Memorandum

To:	Corio Developments Pty Ltd	Date:	15 December 2025
Attention:	Jim McBirnie	Project No.:	229796.00
Email:	jim.mcbirnie@corioprojects.com.au	Reference:	R.003.Rev0
Subject:	DCCEEW RFI Geotechnical Advice, 22-24 Junction Street, Forest Lodge

DRAWING TITLE:  
**INTERPRETED  
GEOTECHNICAL  
CROSS SECTION B-B'**

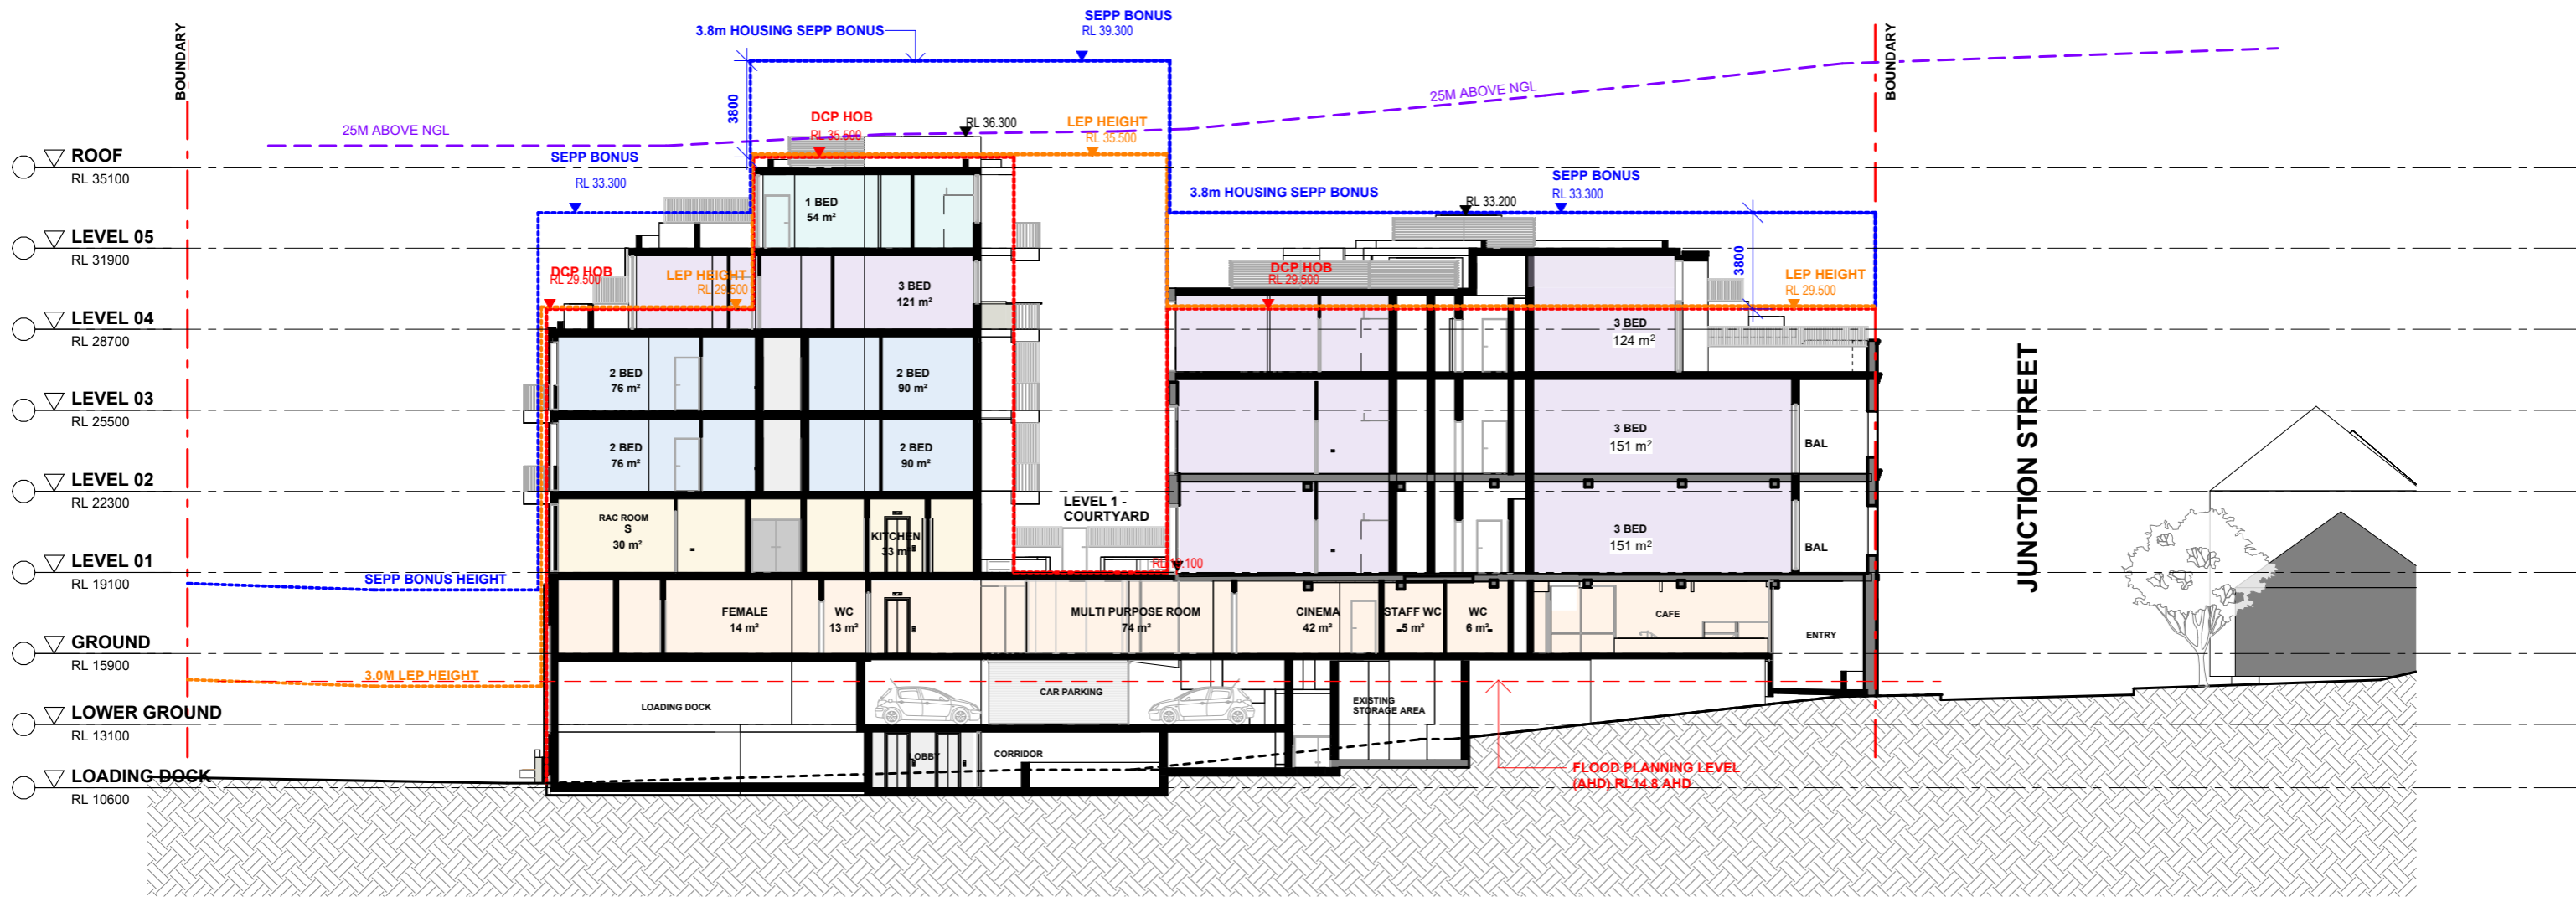
- **Pre-determination**, that the proponent quantifies the maximum annual volume of water take due to aquifer interference activities, noting that “groundwater interception is expected with Appendix 2 (Geotechnical Assessment) stating groundwater was observed at depths below 2.4 m and the maximum excavation depth is 3.5 m”
- **Post-determination**, that the proponent should obtain a water access licence (WAL) to account for the maximum predicted water take for construction and operation activities unless an exemption applies under the *Water Management (General) Regulation 2025*

Response: Reference should be made to Drawings 4 and 5 in Douglas’ Geotechnical Investigation Report 229796.00.R.001.Rev1, which show the proposed finished floor level and discrete groundwater level observations from three groundwater monitoring wells installed in boreholes.

The existing site condition is such that surface levels fall towards the southwest across the site. The maximum proposed excavation depth occurs in the north (highest elevation) part of the site, and the shallowest depth to groundwater occurs in the southwest (lowest elevation) part of the site. The finished floor level (FFL) for the proposed building footprint is RL 10.6 m AHD, with commensurate bulk excavation levels expected to be at about RL 10 m, allowing for some over-excavation. Groundwater levels observed during the geotechnical excavation were between 7.2 m AHD and 8.4 m AHD.

On the basis of the encountered groundwater levels and also the relatively limited excavation depth proposed on the low side of the site, **the proposed excavation is not expected to intercept the perennial groundwater table** and the only groundwater inflows expected to occur would be due to perched ephemeral seepage through the rock mass during and following periods of rainfall (from surface infiltration).
